About the application

Application number: 2020/91978	
What is the application for?:	Part demolition of boundary wall to form new off road parking space (within a Co
Address of the site or building:	22, Town Head, Honley, Holmfirth, HD9 6BW
Postcode:	WF14 8EA

Drawing Title_
AS EXISTING + PROPOSED STREET SCENE ELEVATIONS

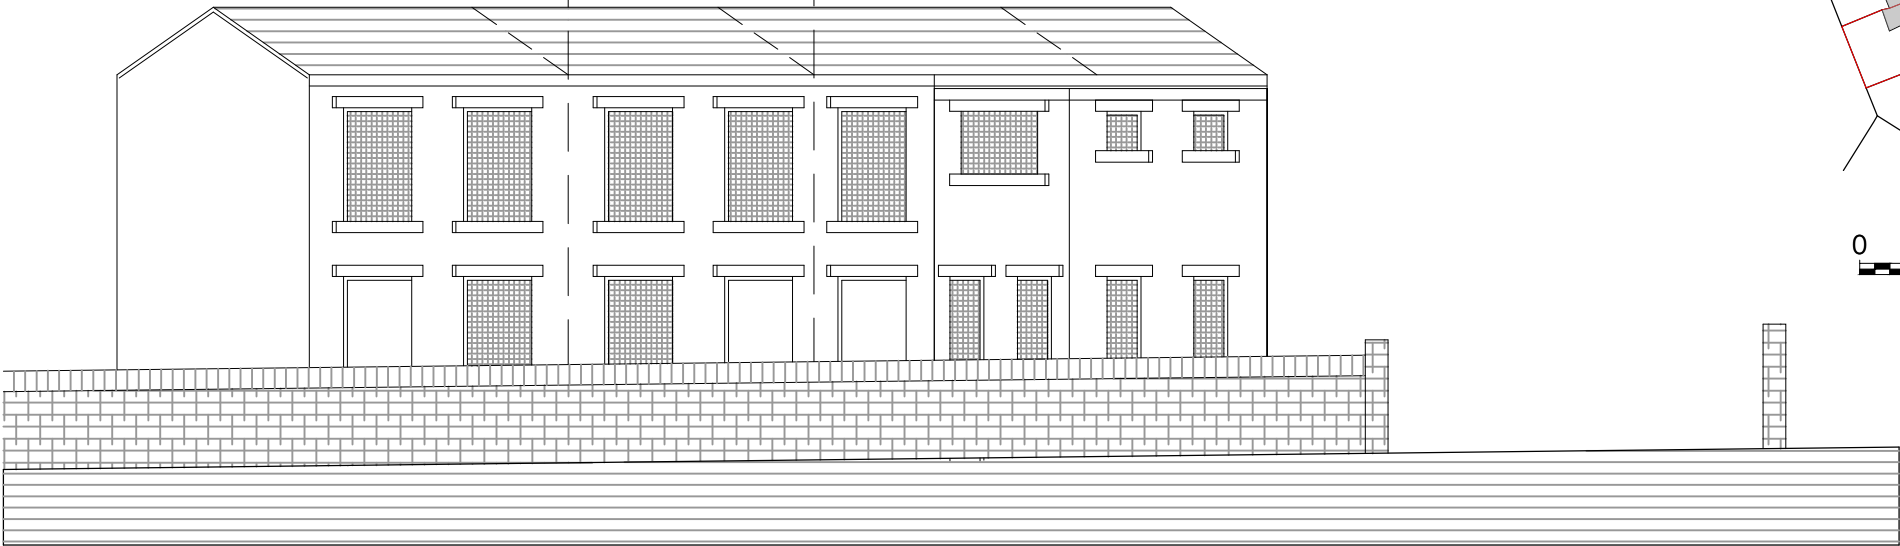
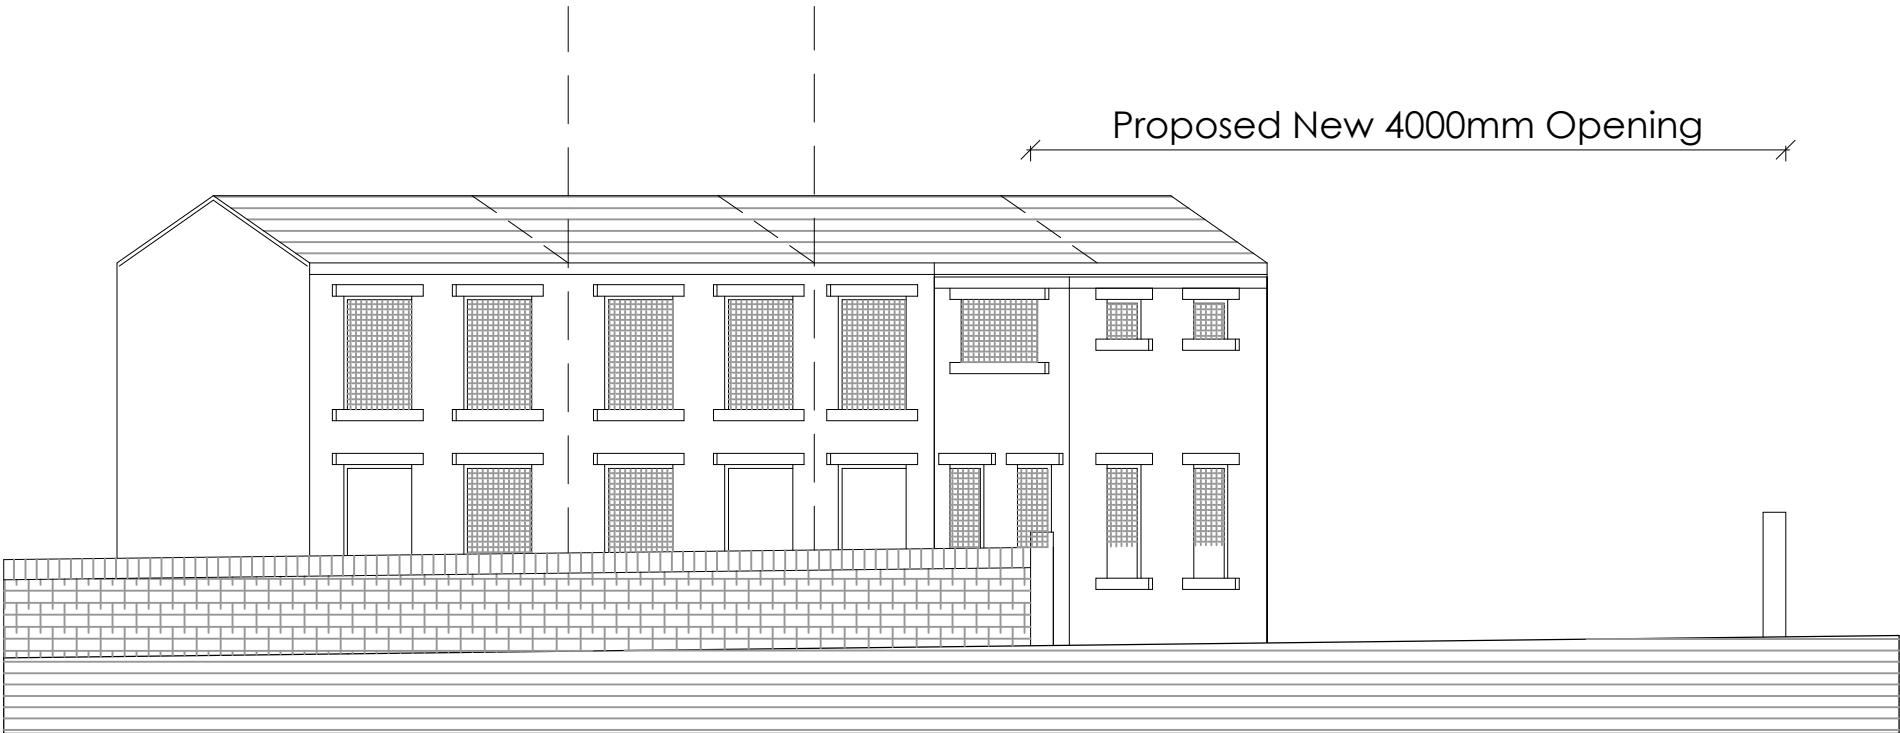
Type of comment: An objection
The wall in question is an attractive, defining feature in the street, which reflects the history and development of the Town Head area and contributes to its character; it should therefore be preserved. The demolition of the wall would have a negative effect on the appearance of the street, and the introduction of hard standing for vehicles would erode the special character of the area. The Victorian terrace of which number 22 forms a part, relates to older surrounding buildings and to the boundary wall - the only current opening in the wall appears to predate the building of the terrace and thus reflects the site's history and original (agricultural) functions. Contrary to the statements in section 7 of the planning application, the proposal would create a new vehicle and pedestrian access onto the public highway, which has not been addressed. The proposal to block the footpath will presumably have to be withdrawn, as it is clear that there are historic rights for people to cross the land in front of number 22 to access their own property and to access the outhouses; their only alternative would be to make another undesirable breach in the wall. Although the works may not have started on the date of submission of the application, they have certainly been started without consent, as a skip load of topsoil was removed on 1 August 2020; and since then paving stones and gravel have been laid down. Of more concern is the damage to the wall that was caused on either the evening of 1 August or, more likely, the following morning: it is now bowed inward when it was previously perfectly upright throughout its length (as can be seen from the photo in the design and access statement).
